File No. D02-02-20-0035 and D07-12-20-0056

December 8, 2020

Subject: Zoning By-law Amendment and Site Plan Control (Complex) Applications- 243 and 245 Hinchey Avenue

FRONT AND SOUTH SIDE ELEVATIONS

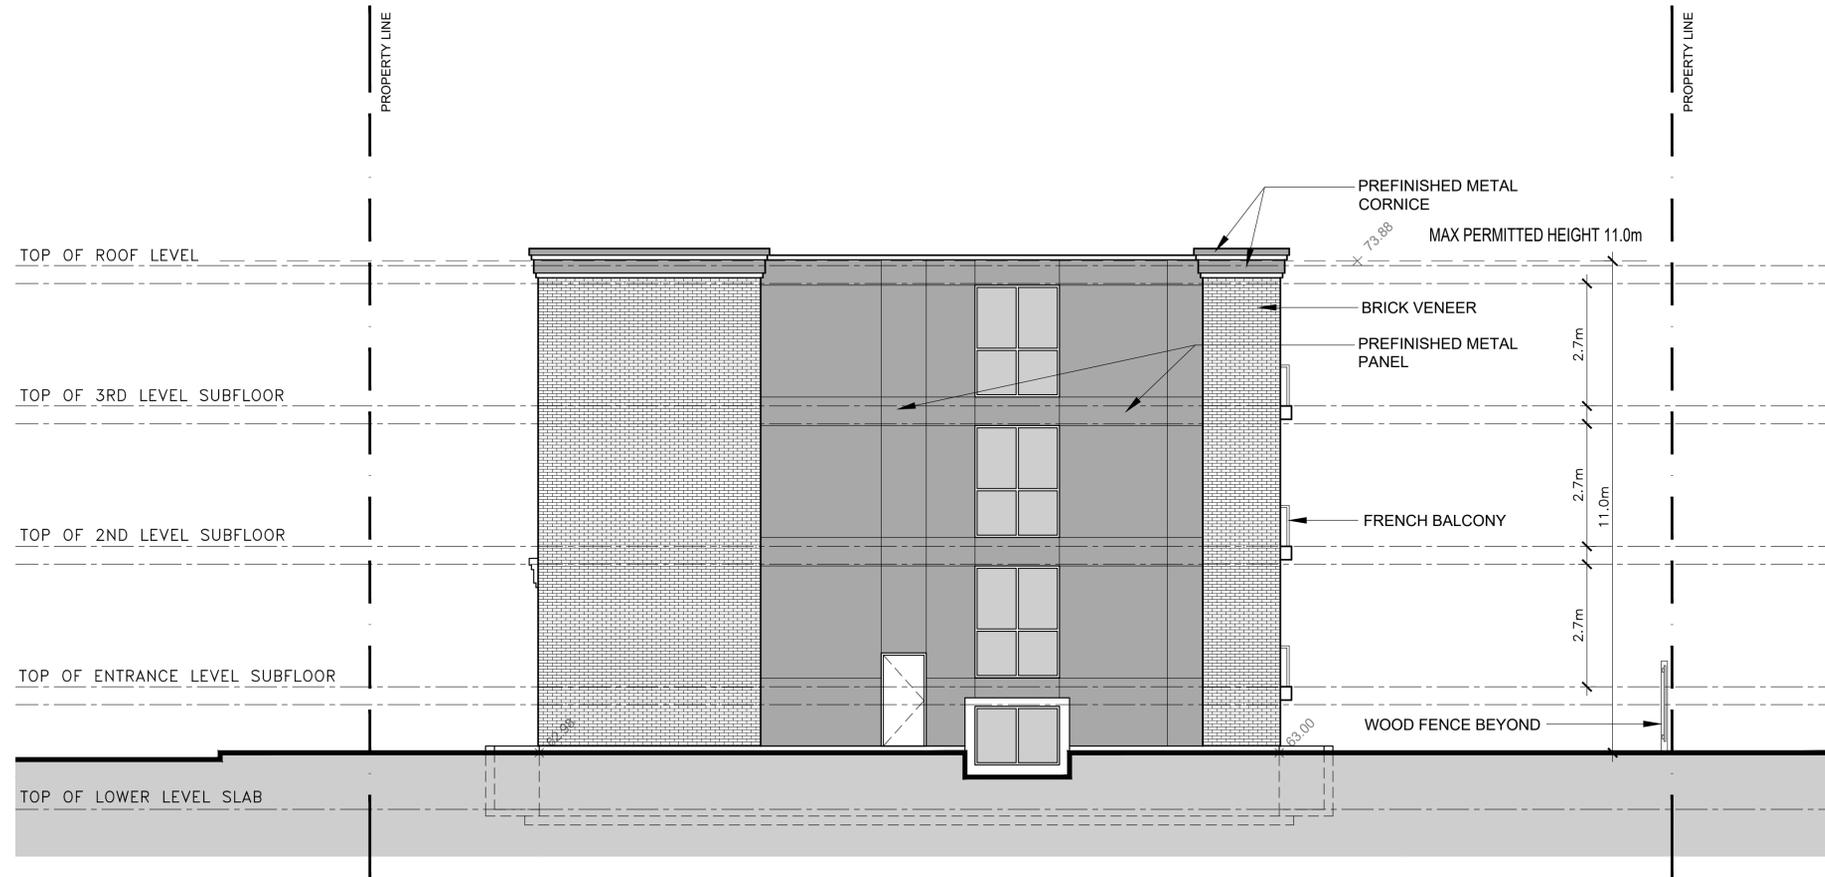
8. Please consider utilizing masonry as opposed to sheet metal for the sides of the building, especially given the viewpoint from Scott Street. **Modified**

1. Staff continue to recommend that masonry be reconsidered around the main public entrance and that the choice of a metal surround for the entrance is a detriment to the street facing façade; **Noted.**

DRAWING TITLE  
REAR AND NORTH SIDE ELEVATIONS

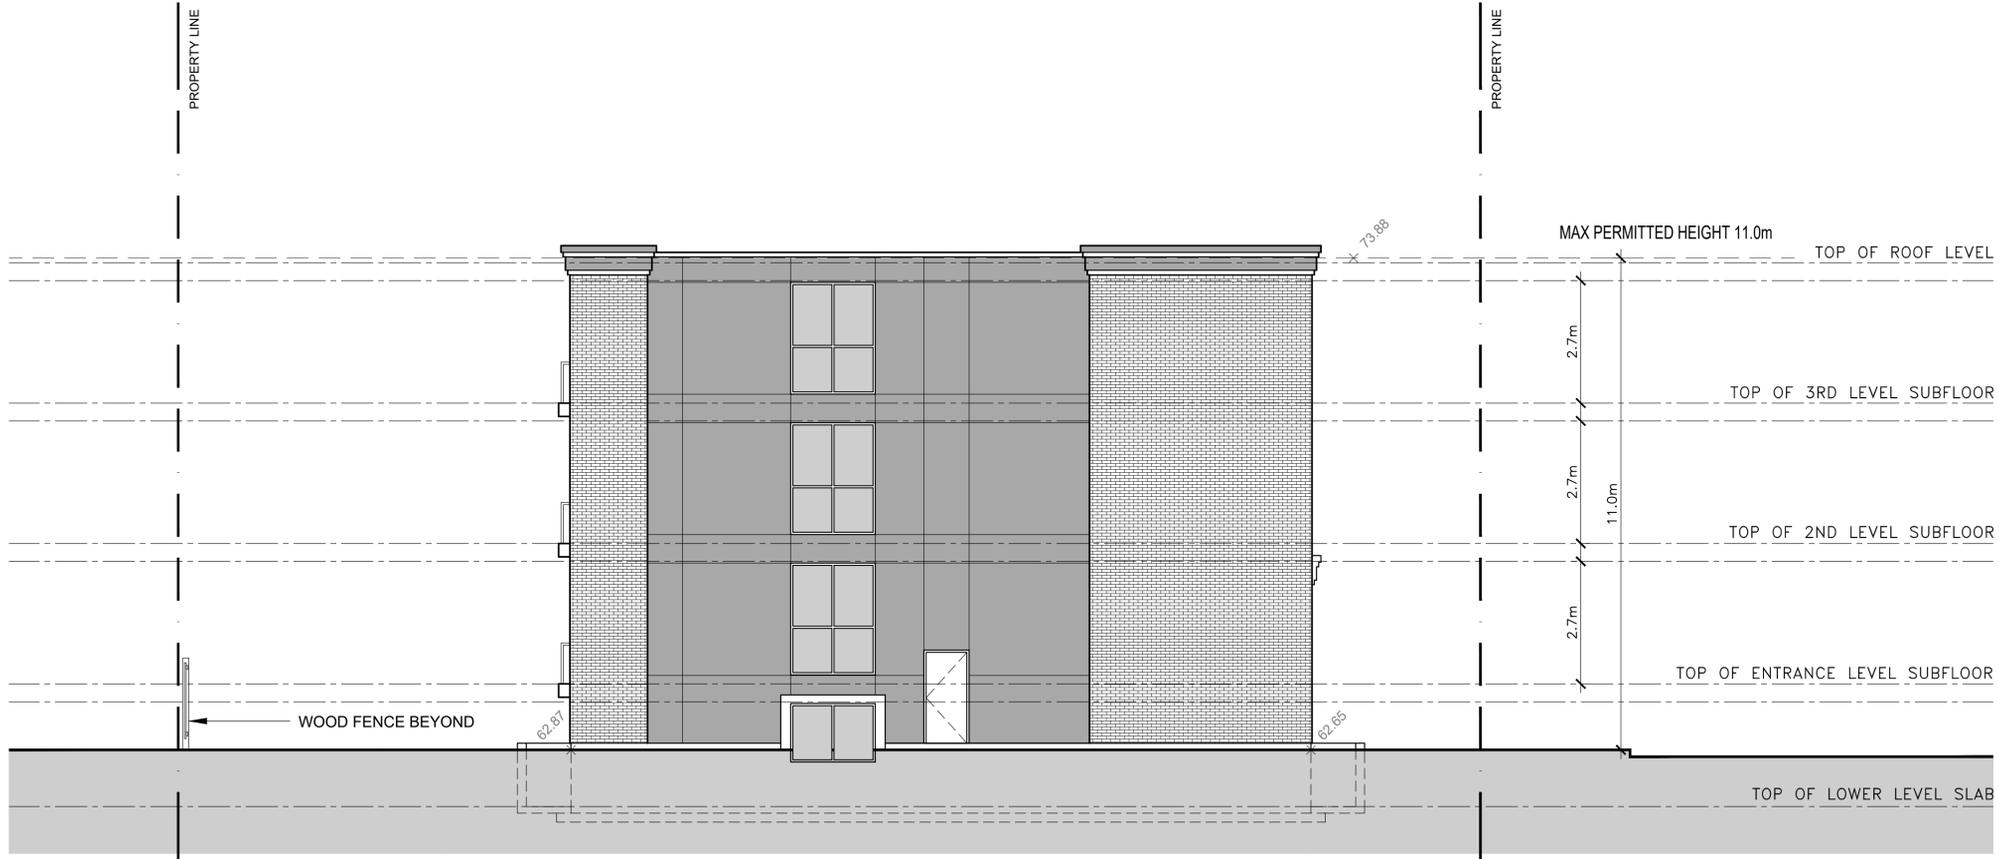
12. The Rear elevation still shows Juliet balconies on all three levels, yet these are not shown on the Site Plan. Please ensure the Elevations and Site Plans align. **Juliet balconies removed from all plans.**

2. It is still recommended that the north façade visible from Scott Street be considered for an improved façade treatment as this view is highly visible from Scott Street and will likely be protected for a significant period of time due to the ownership of land to the north;
Modified

SITE PLAN

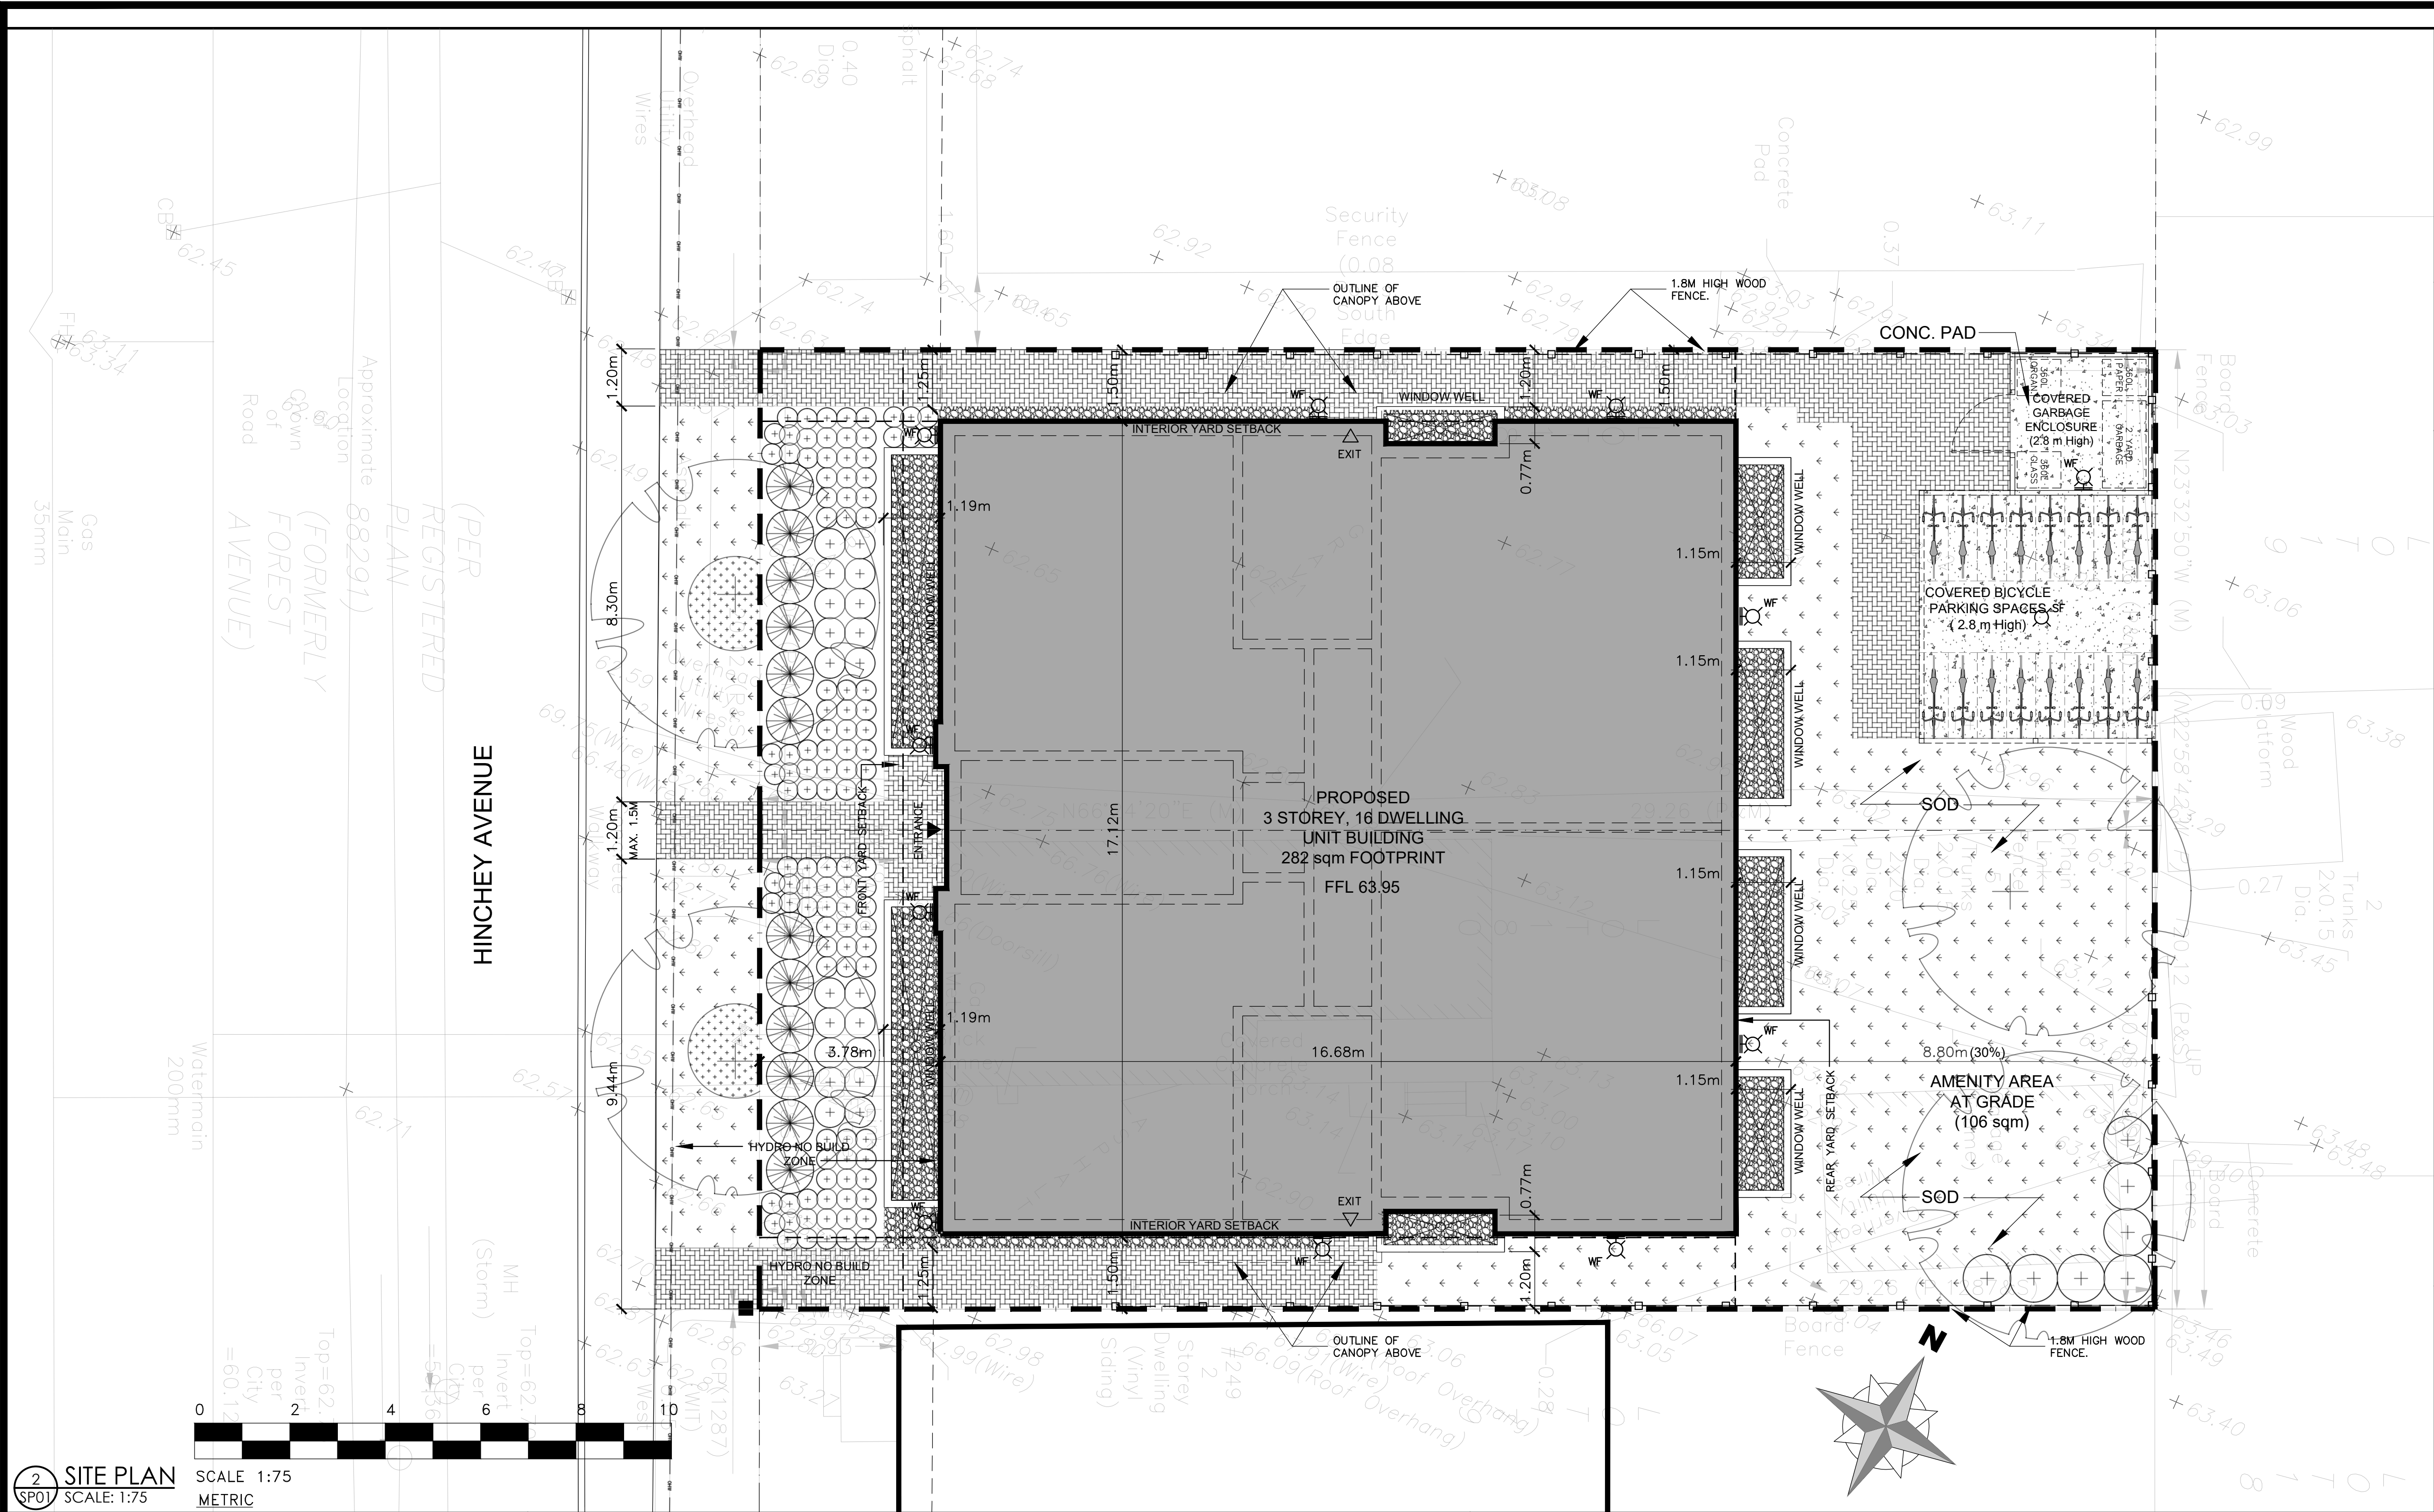
2. Please ensure that the Zoning Table shown on the Site Plan includes information on the accessory structures as the rear, as per Section 55 (i.e., setbacks, height, size in square metres, et cetera). **Provided**
3. The Site Plan shows landscaping in front of the right-hand corner of the building (beside the window well), yet the Landscape Plan does not (see part of comment 5). Please ensure the Site Plan and the corresponding Landscape Plan align. **Both drawings indicate that no landscaping is to be provided there as that is the location of a Siamese connection.**

4. There are three hard paved paths proposed, one leading to the main entrance, one leading to the interior side yard and the rear, and the third leading to an entrance/exit on the other interior side yard (abutting 249 Hinchey). In order to comply with the new provisions for landscaping under Infill and the R4, both adopted at the Council meeting of October 14th, 2020, it is recommended that this third pathway be replaced with mulch and patio stones (thus still functioning as a walkway, but also increasing the total landscaped percentage). **The third path has been re-instated. We have removed the hard paved path that runs parallel to the front lot line and the front wall of the building between the three paths that connect to the sidewalk and this has increased the soft landscaping % as a result to ensure zoning conformity.**

3. We believe that the south path, leading to/from a secondary entrance must lead to the public right of way by code, please check that, and the portion of interlock leading to the front entrance which duplicates the sidewalk is unnecessary as identified in the last review 09/22/2020 (see 243-245 Hinchey Ave_SK-1); **South path now connects to the sidewalk**

1. The new Infill Regulations (By-law 2020-289) set out a minimum requirement for 40% of the front yard to be aggregated into a softly landscaped area. While a walkway may pass through the softly landscaped area, it appears that the number of walkways used in the front yard is unnecessary for the site. Reducing or removing one the connecting portions between the two walkways to each side of the building would increase the amount of soft landscaping and ensure further relief under the new Infill provisions is not required.
Paths at the front of the site have been modified at the front of the site to make it zoning compliant

2. Section 161(13)(d) of the new R4 provisions specifies a minimum area of soft landscaping in the front yard, which in this case (front yard more than 3m and lot more than 12m wide) is 40%. Please denote on the Site Plan whether the proposal meets this threshold. It is unclear what the functional need of having a 2-metre(?) wide pathway at the front is needed for. If possible, to reduce (while maintaining accessibility requirements) and slightly increase the ability to soft landscape more of the front yard, please do so. **Plans modified to meet zoning requirements**

3. Under the new R4 provisions, landscaping is key, which includes the provision of trees. Please consider adding an additional tree at the rear (consider moving the proposed tree at the rear slightly closer to the bike parking and accommodate additional landscaping in that area, if possible) **Additional tree provided in the rear yard.**
